CITY OF ALBUQUERQUE

March 29, 2012

Re: Professional Office Building, 1110 Second Street NW, Amended Traffic Circulation
Layout Architect Stamp dated 10-19-11, (J14/D001)

The amended TCL submittal received March 27, 2012 is **not approved** for Building Permit.
The following items need to be addressed to the satisfaction of the City prior to approval.

Site Plan - New
1"=10'

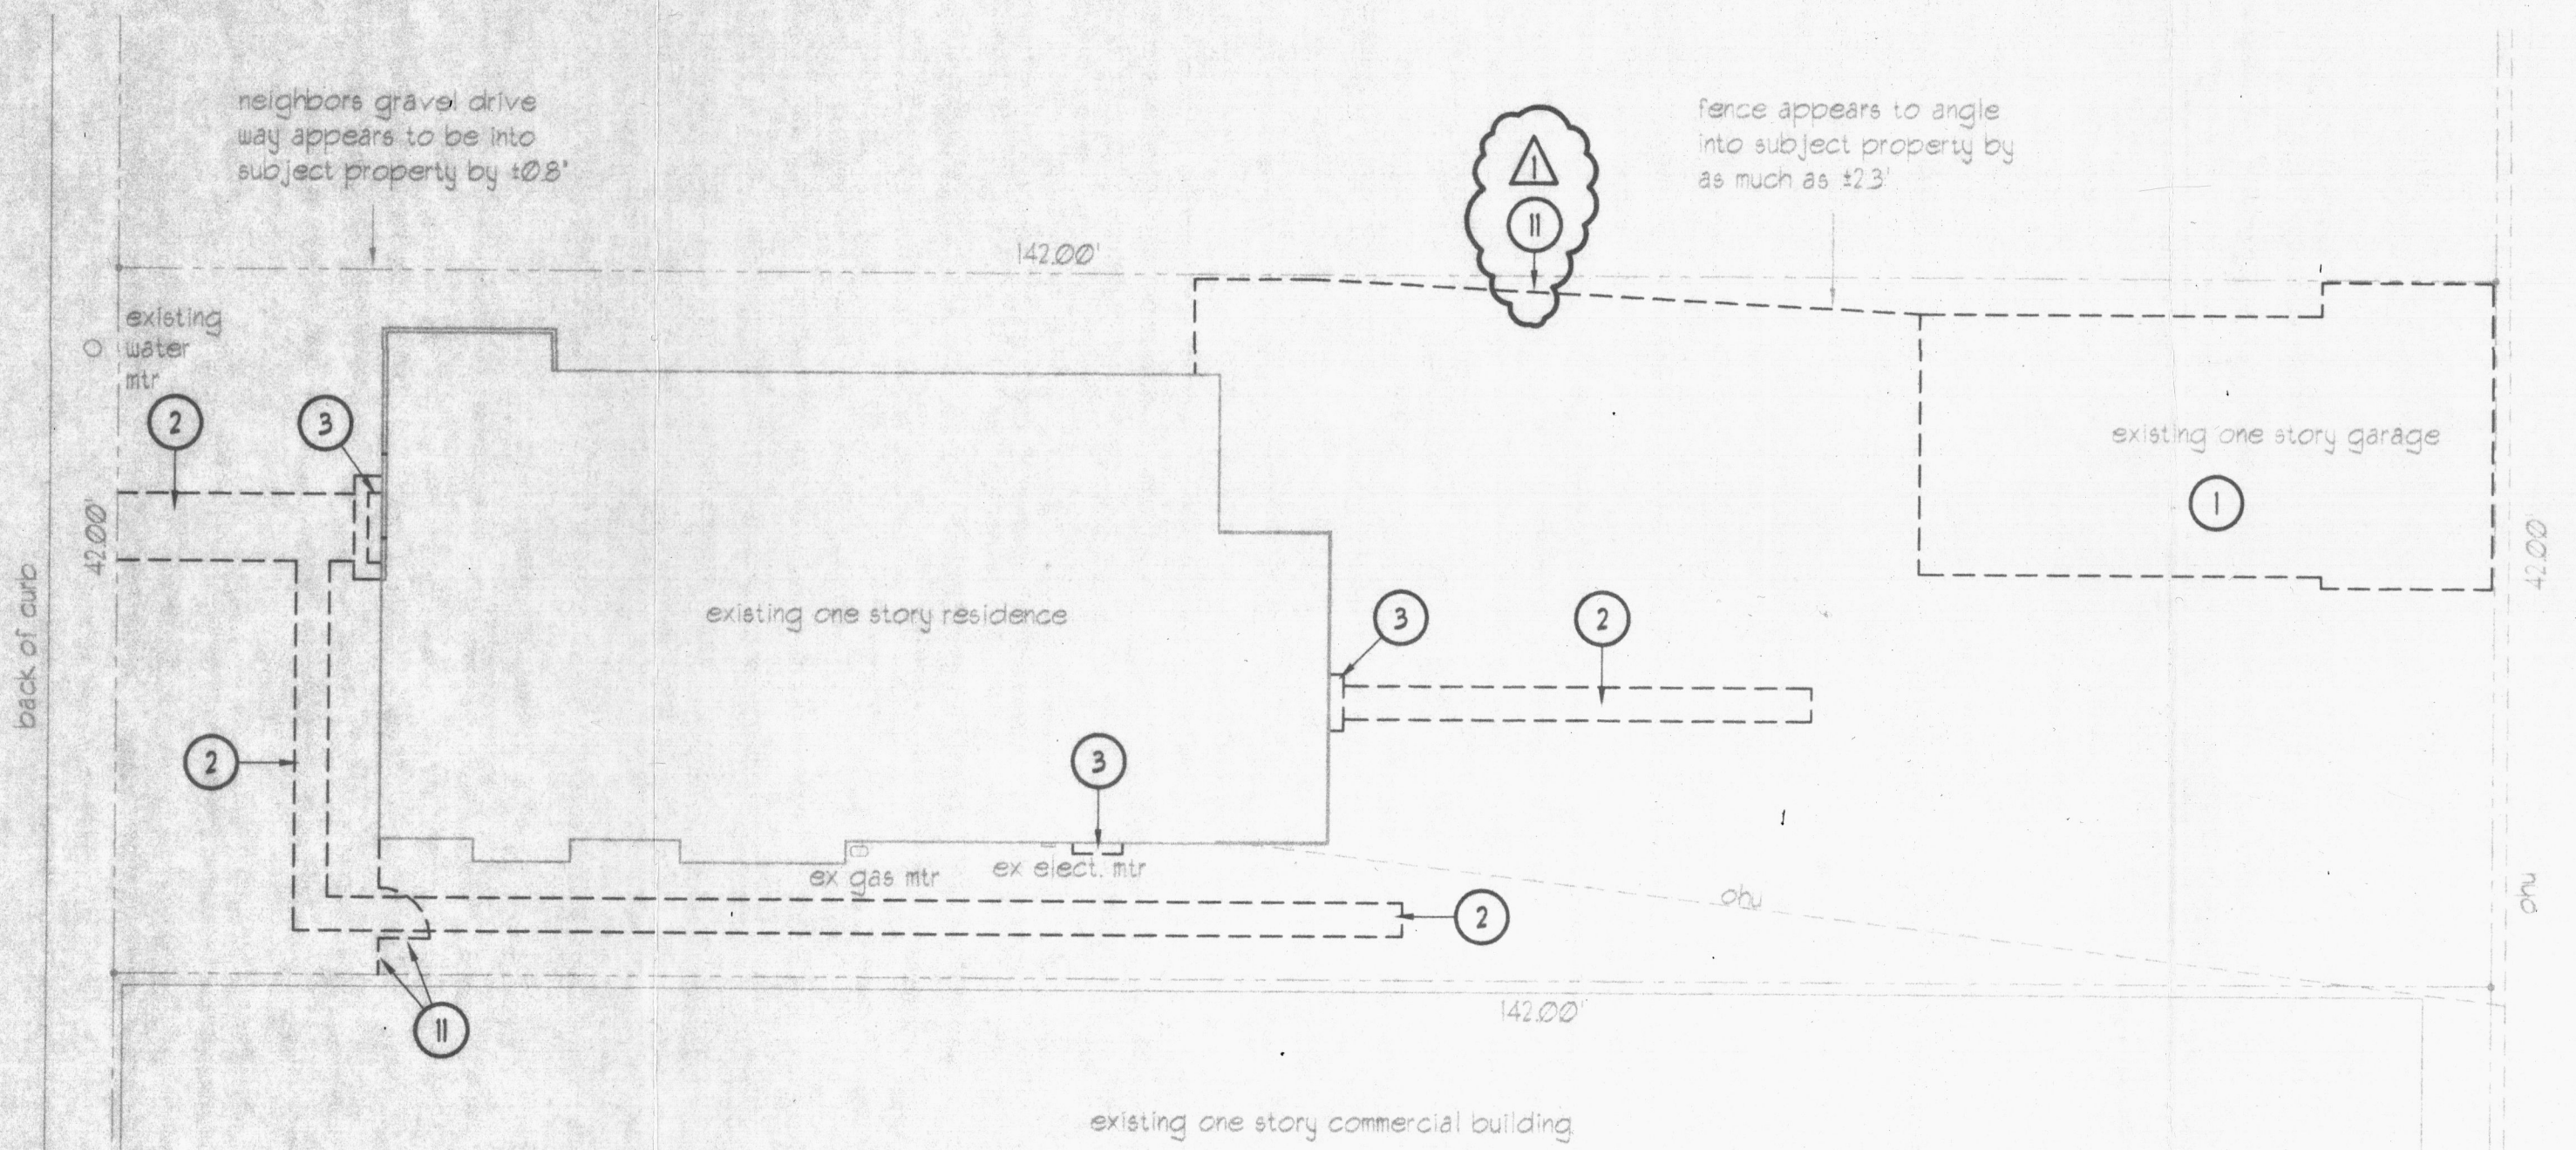
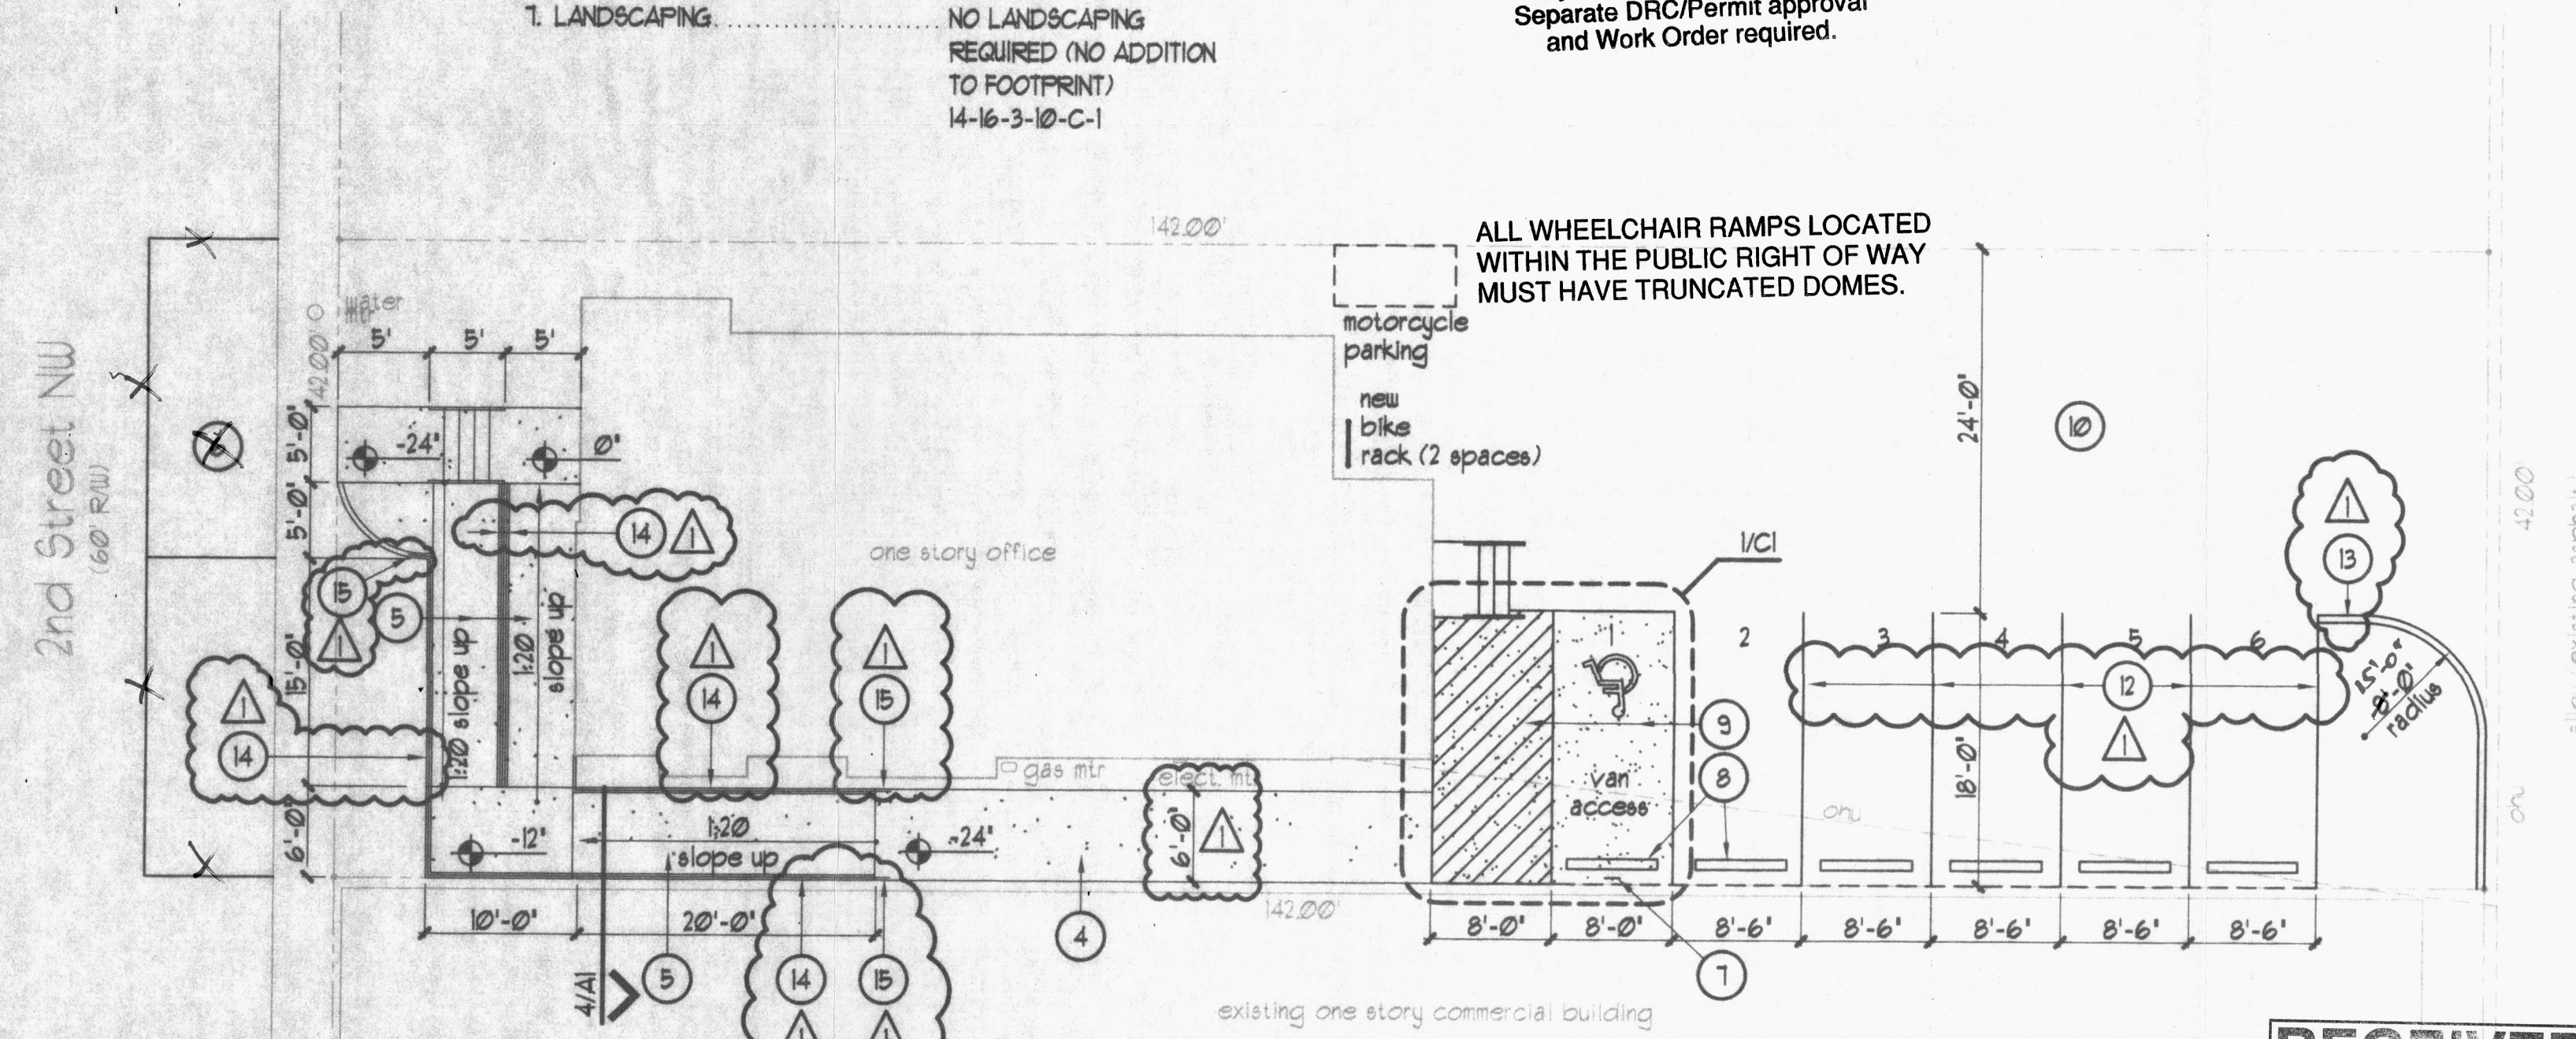
1. The parking lot for this site is required to be asphalt paving in accordance with the City Zoning Code, 14-16-3-1-(E)(1).
2. The new rolling gate is required to be contained onsite, not within City right-of-way along with the fence, please note this.
3. The Architect stamp for this plan needs to be updated.
